<b>Application Ref:</b>	3/2025/0988			 Ribble Valley Borough Council www.ribblevalley.gov.uk
<b>Date Inspected:</b>	29/01/26	<b>Site Notice:</b>	29/01/26	
<b>Officer:</b>	LW			
<b>DELEGATED ITEM FILE REPORT:</b>				<b>APPROVAL</b>

<b>Development Description:</b>	Proposed loft conversion with insertion of rooflights and replacement including extension of single storey rear infill extension and associated works including sash window replacement.
<b>Site Address/Location:</b>	Rodhill, 10 Clitheroe Road, Whalley, BB7 9AB.

A9a

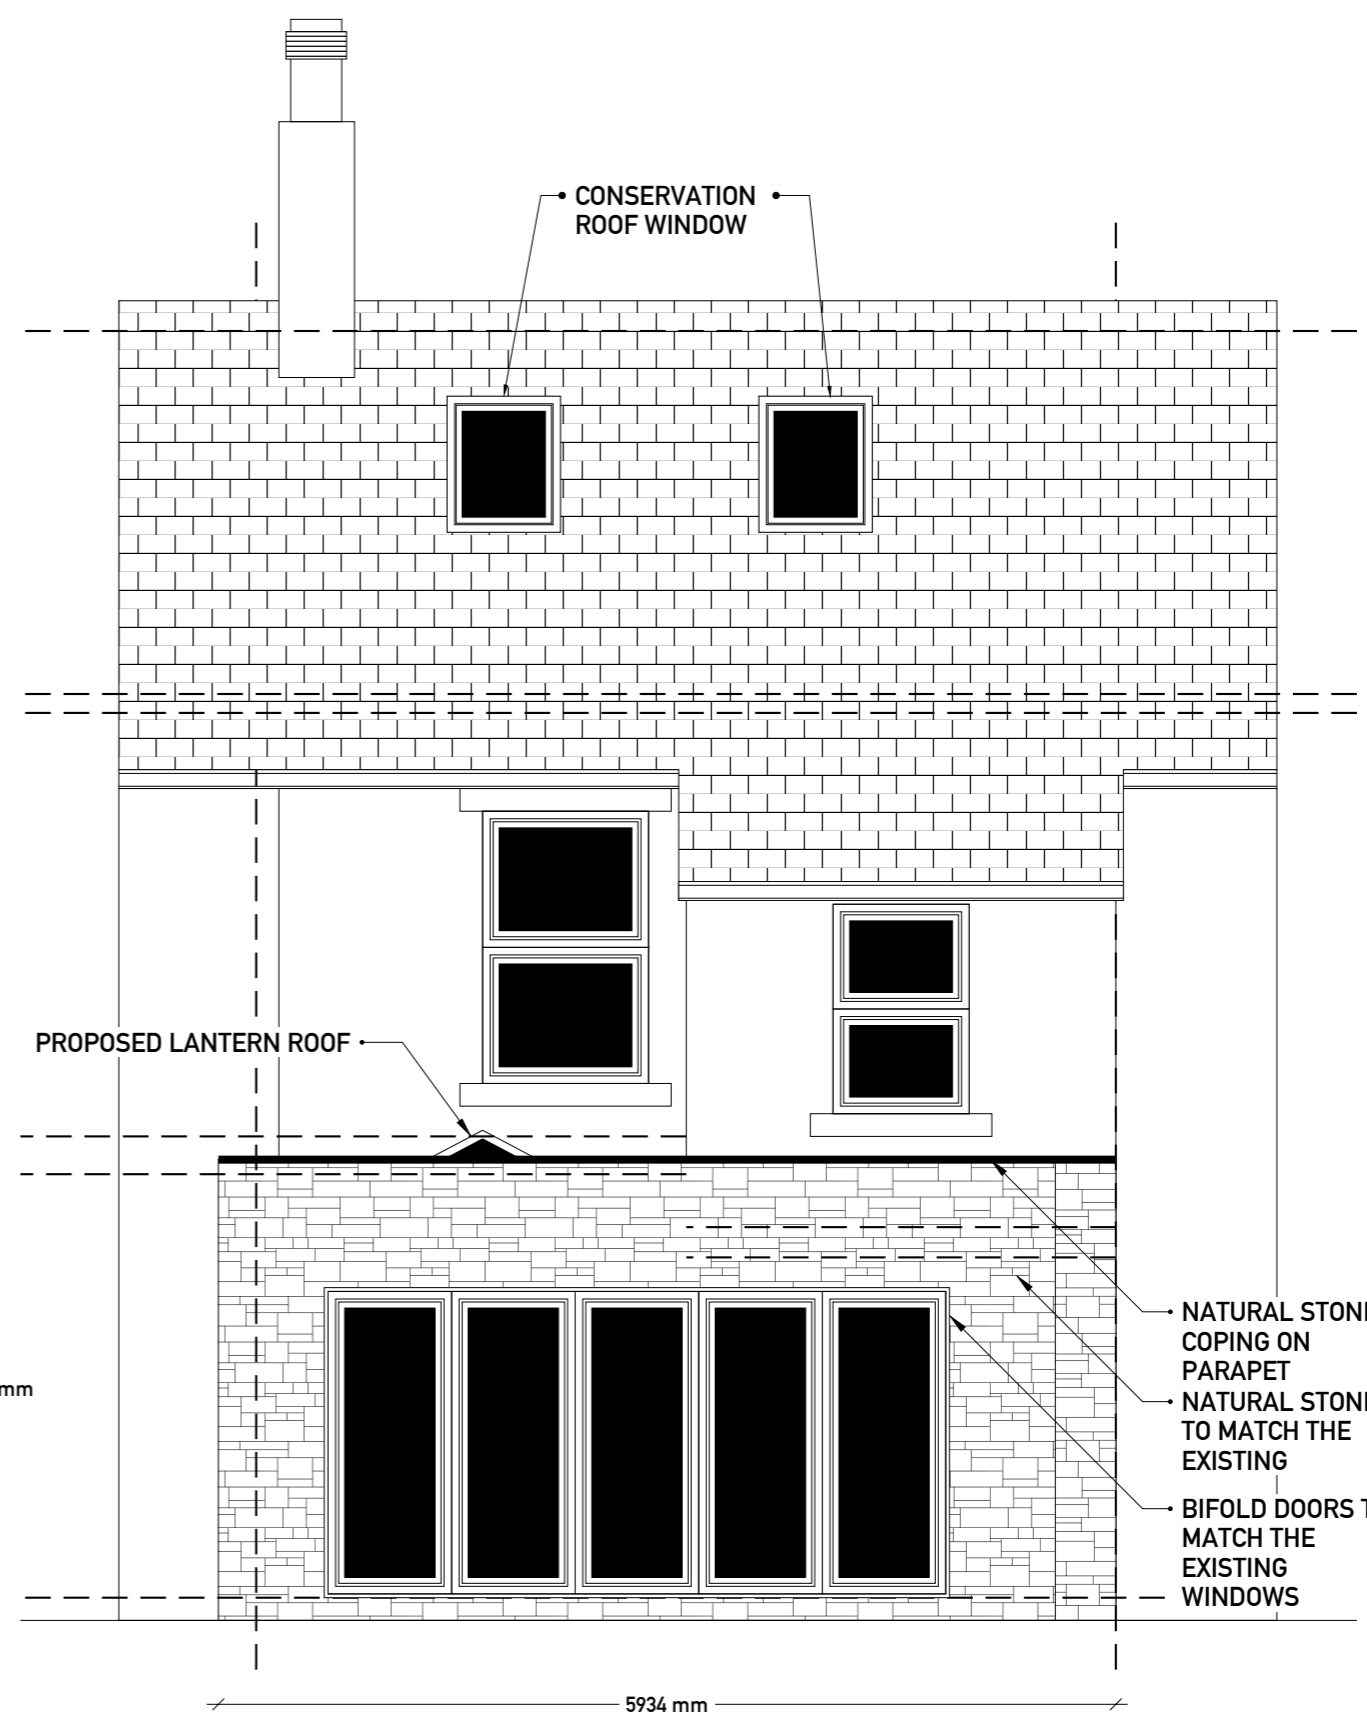
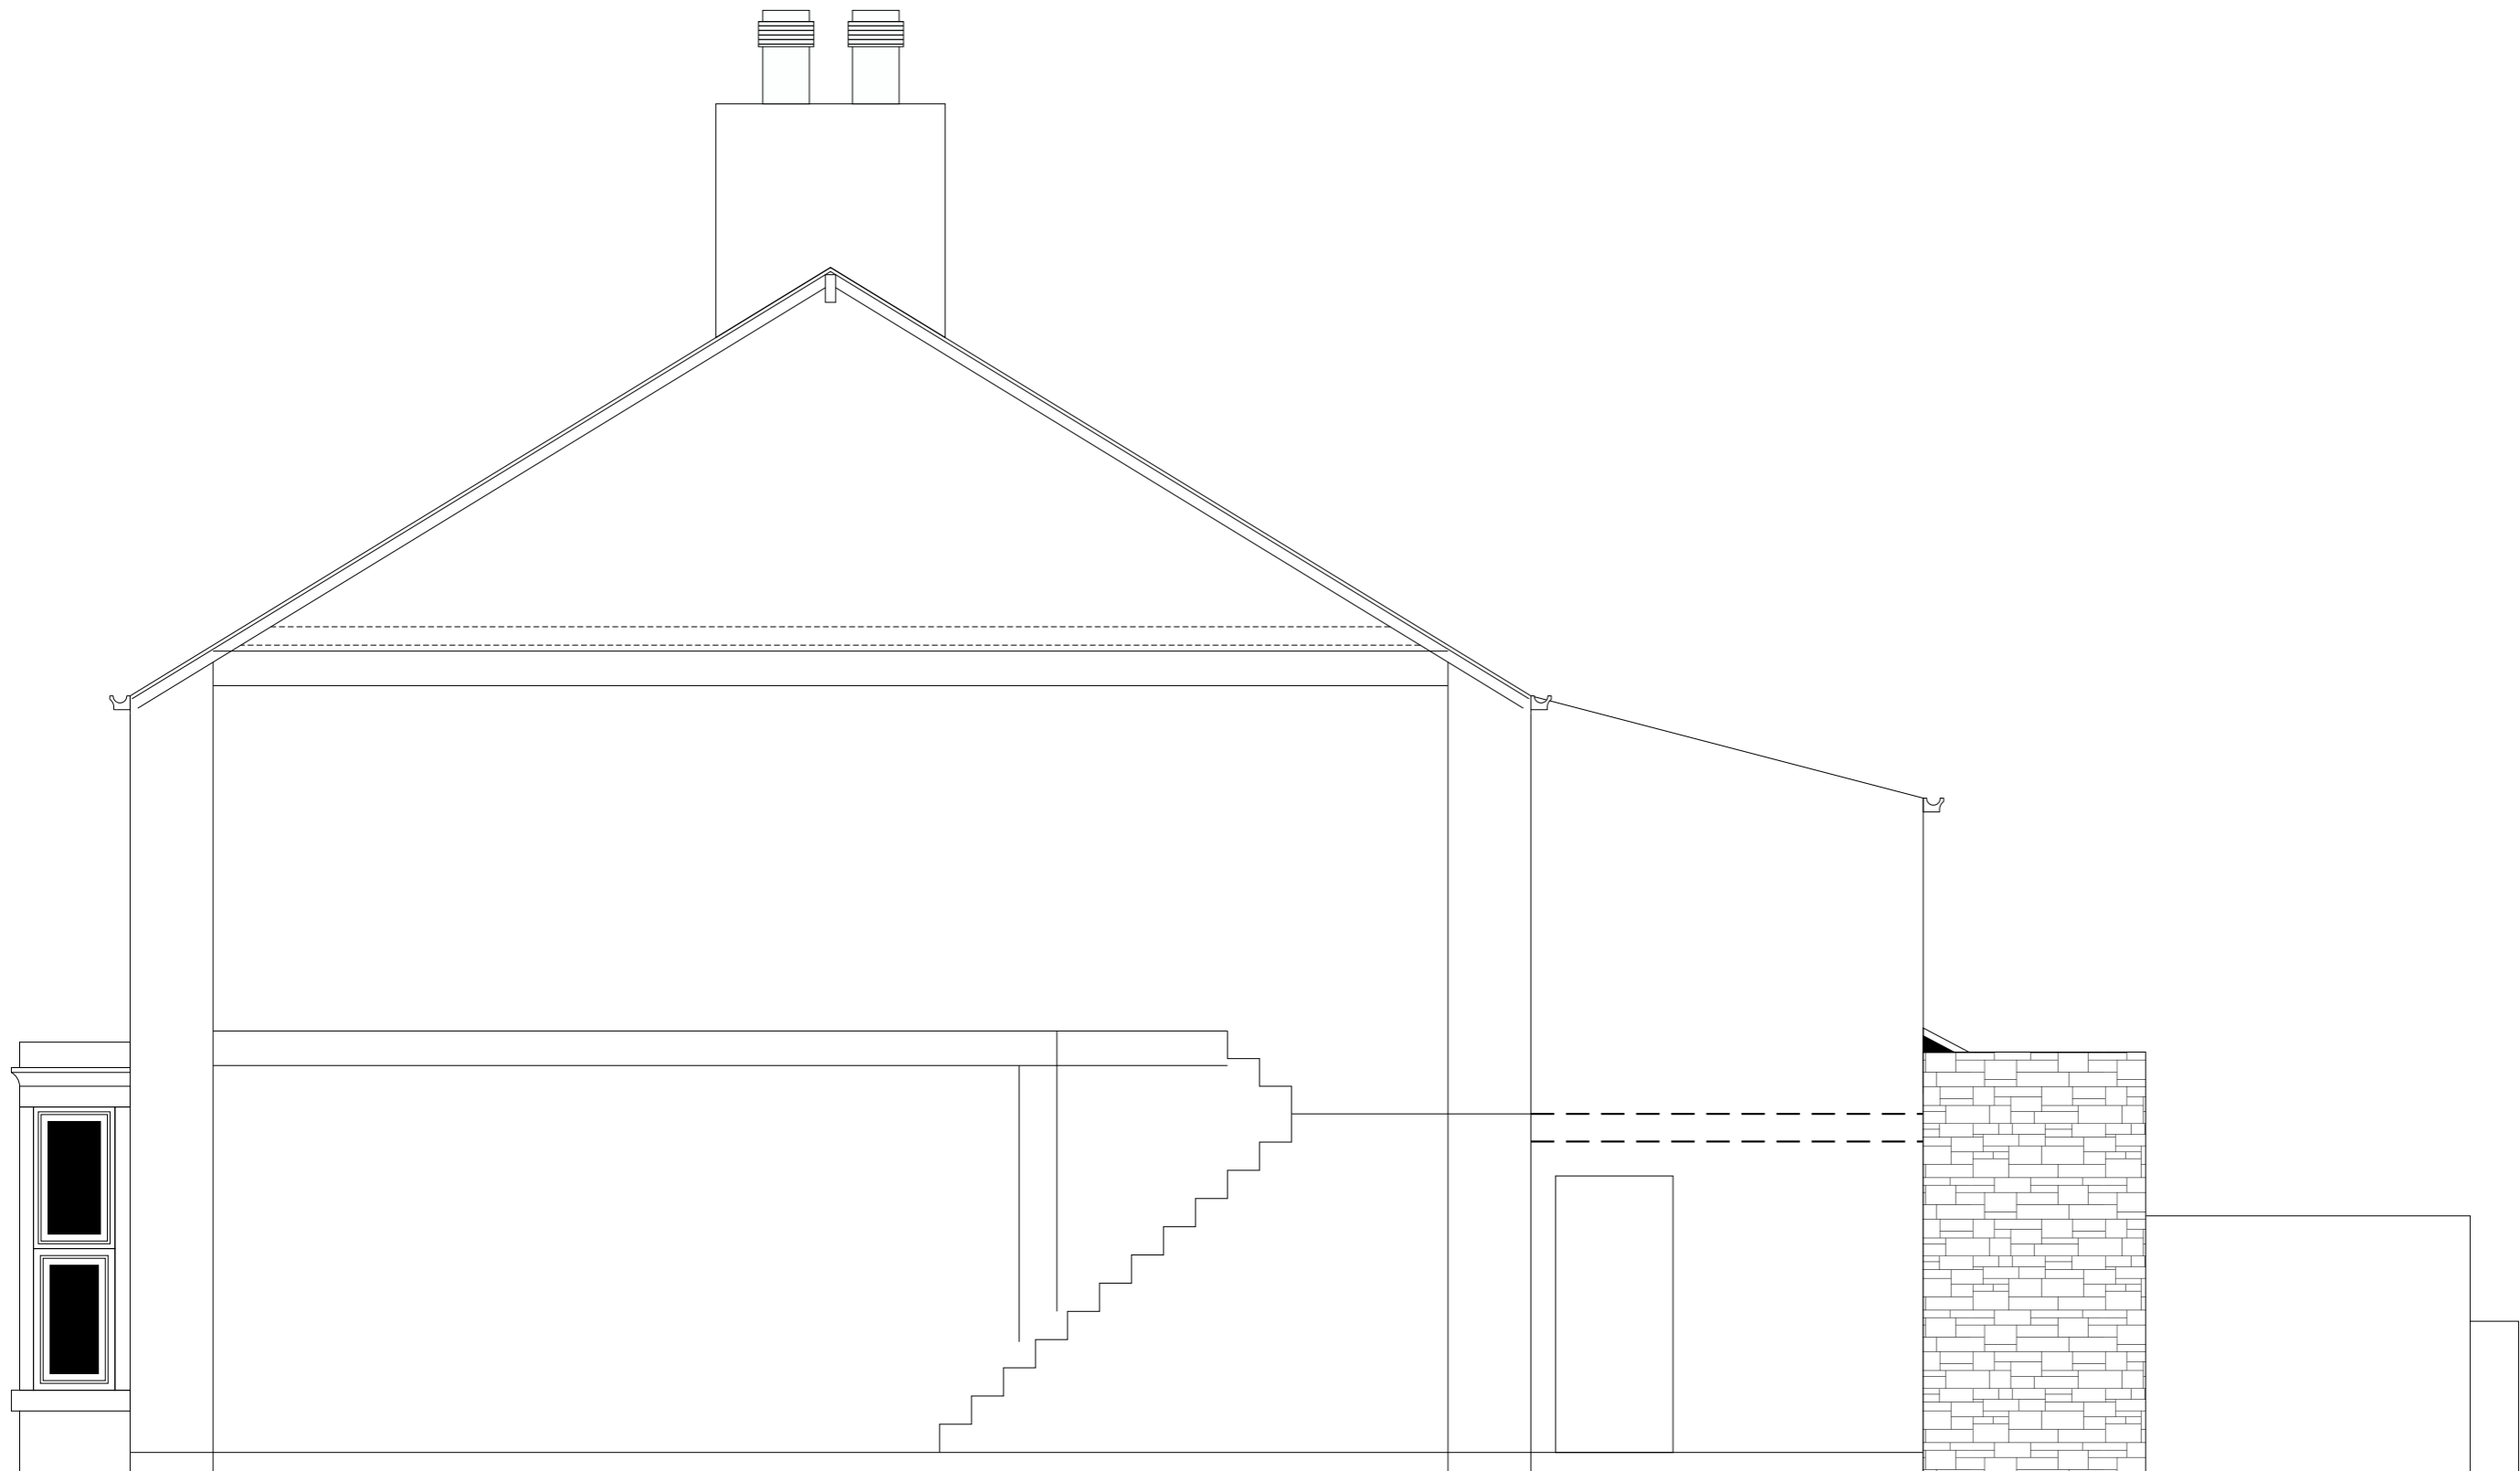
With respect to the single storey rear extension, this would replace the existing single storey sunroom and store and would remain appropriate in size and scale when read in context with the existing built form of the dwellinghouse. While the proposed flat roof and aluminium bifold doors would result in a relatively modern appearance, the overall design of the extension would not be dissimilar to the existing single storey additions featured to the rear of adjacent properties, namely Nos. 14 and 16 Clitheroe Road. The use of stone would also match the external appearance of the existing property, ensuring visual integration and further reducing the impact of development.

It has also been requested that confirmation be provided that the side elevation of the proposed extension, which will form a party wall, will be finished in stonework. The development is proposed to be constructed from stonework, as stated within the submitted application form and shown on the proposed plans, with a condition imposed to secure this.

A8

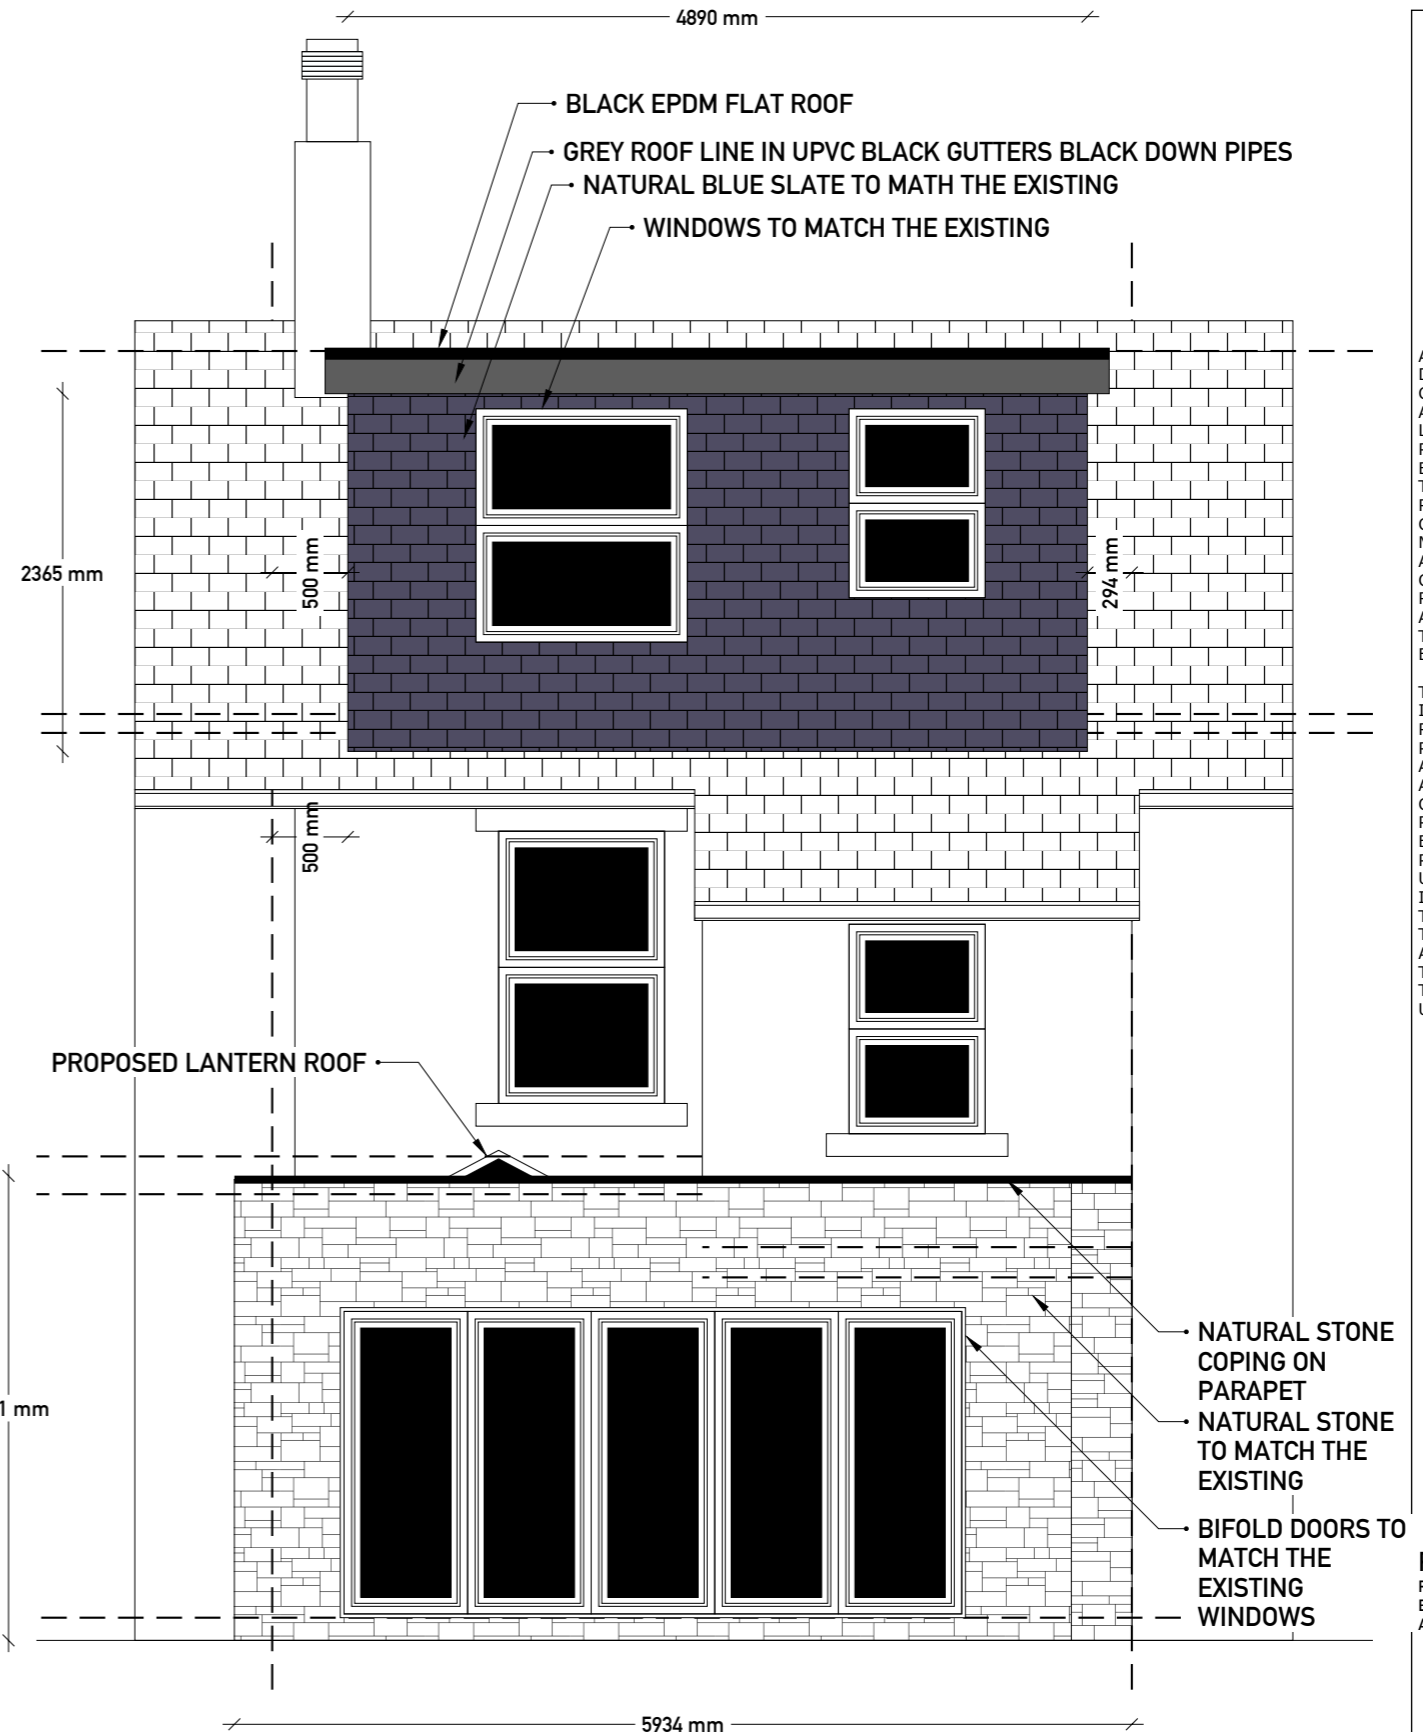
With respect to the proposed development itself, the scheme originally submitted with the application included the construction of a large box dormer to the rear of the property. Although it is recognised that the rear elevation of the terraced row is not afforded a high level of public visibility, the rear roof slope is partially visible from Brookes Lane which would result in the proposed addition having some visual impact upon the surrounding area. In this respect, it is noted that the rear of the terraced row has undergone substantial alterations over the years, including alterations to the original cat-slide mono-pitch roofs of the two-storey outriggers featured to the rear of each terraced property and the construction of single storey extensions of varying forms. However, the main roof profile of the terraced row has remained largely unaltered which has helped to preserve the inherent character of the row. As such, it was considered that the proposed box dormer, if implemented, would result in detrimental harm to the existing character and visual amenities associated with the building.

Following discussions with the Agent, the scheme has been amended. The dormer has been removed and is instead replaced by the insertion of two conservation style roof lights within the existing rear roof pitch of the dwellinghouse. This is considered acceptable, insofar that the resultant visual impact upon the terraced row and wider Conservation Area would be limited.
